Project Modifications

In response to the workshop and comments we have received from the Historic Preservation Board Gawron Turgeon Architects has made the following revisions:

SHEET TITLE
THIRD & FOURTH
FLOOR PLAN

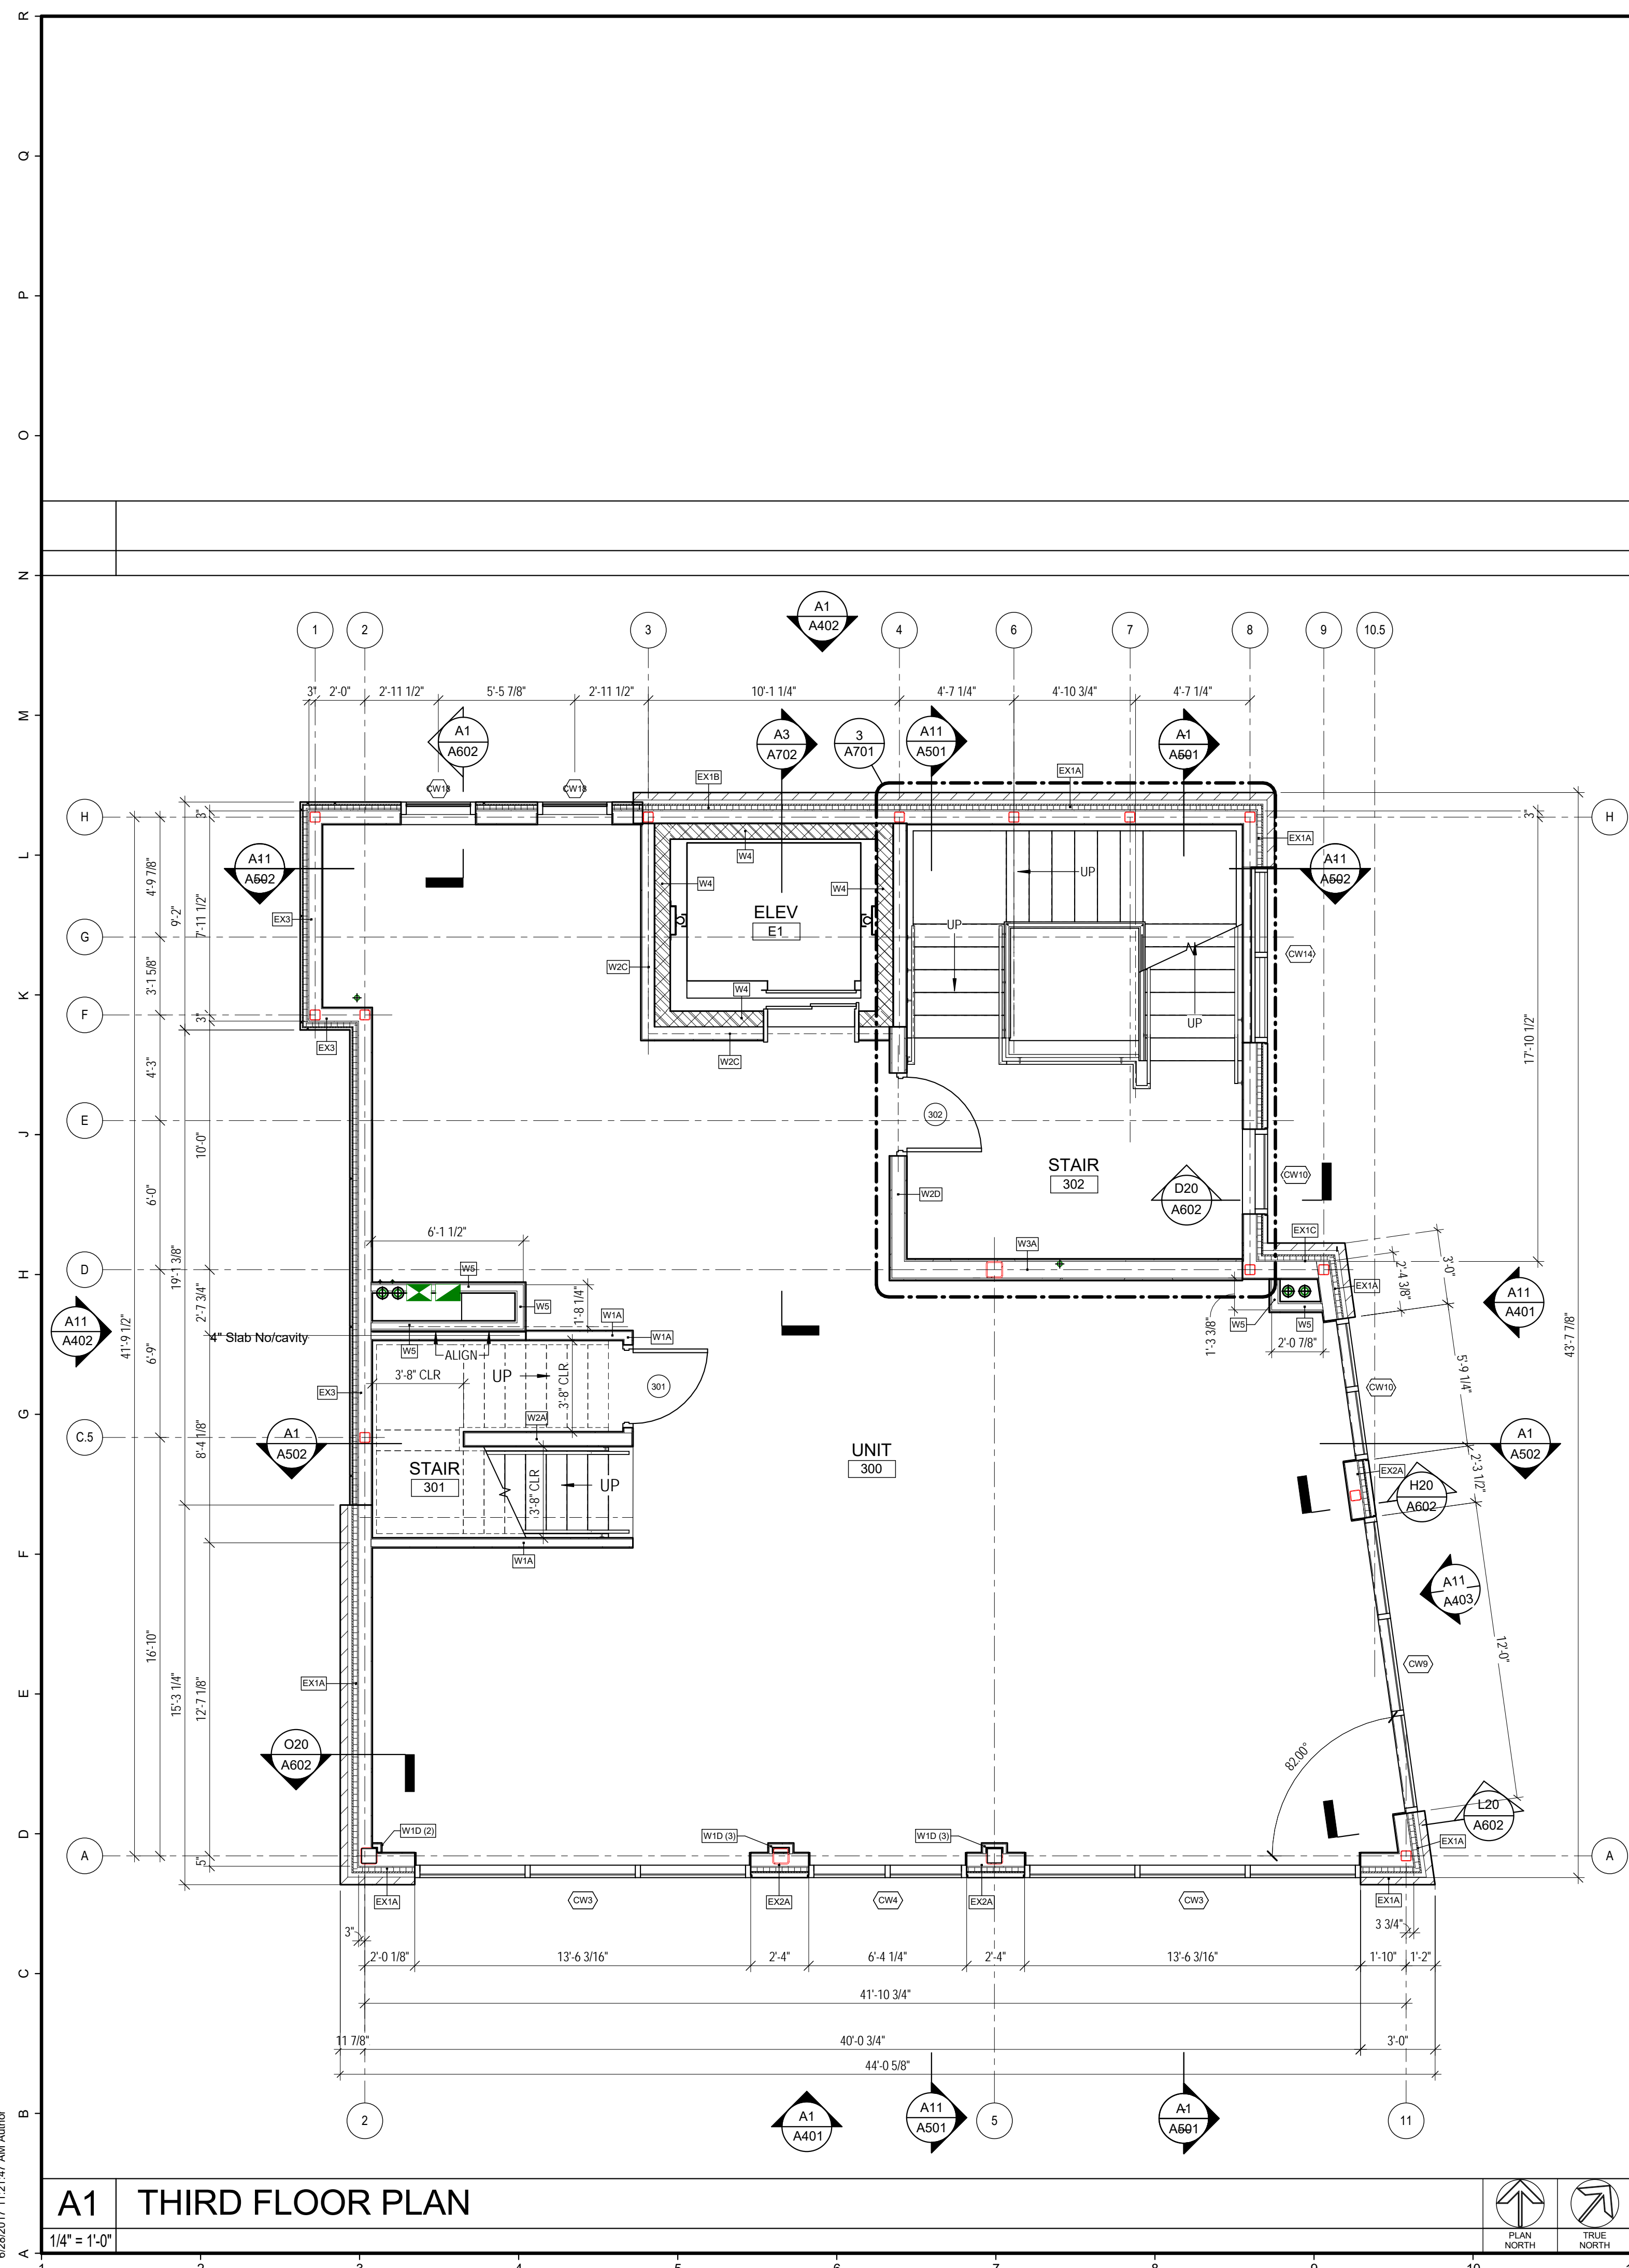
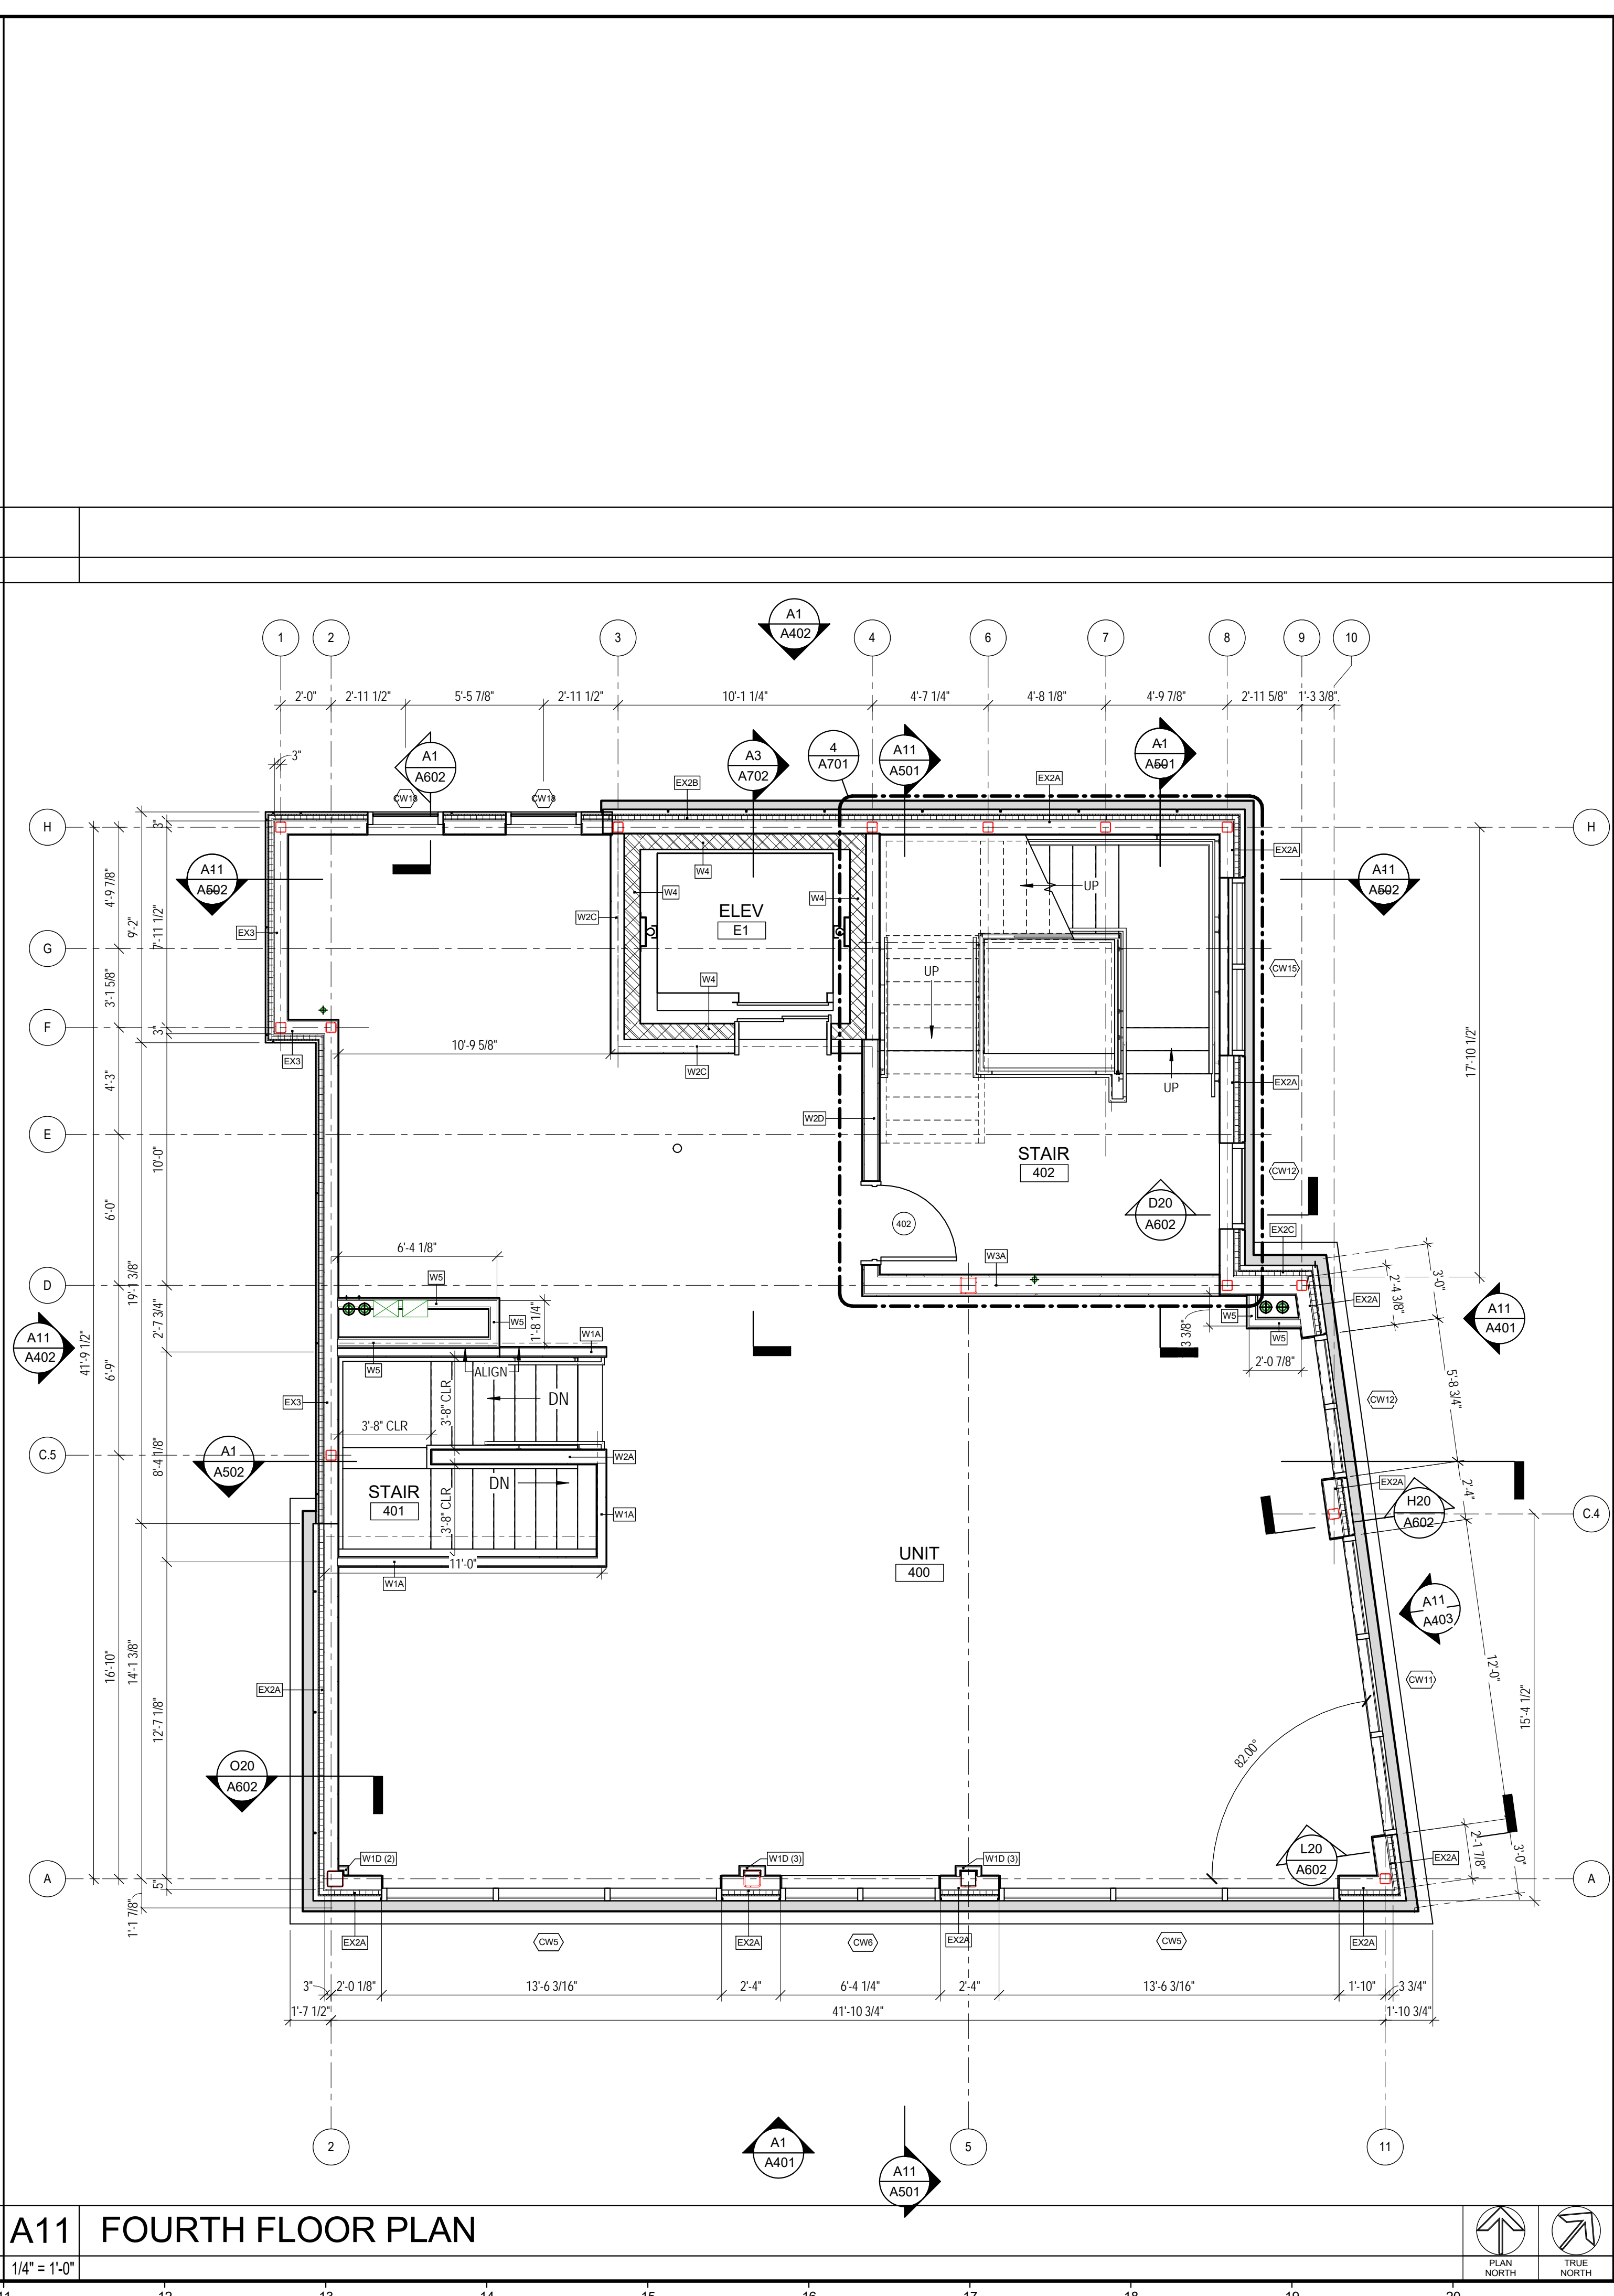
- The elevator tower is now a 4 stop elevator and does not go to the roof deck level – eliminating the over-run extension. The max height of the building at the service location is now 57'-9 3/8" with the height of the fourth floor top of wall being 47'-10 1/4" . Allowable fourth floor height in the UA district is 50'-0"
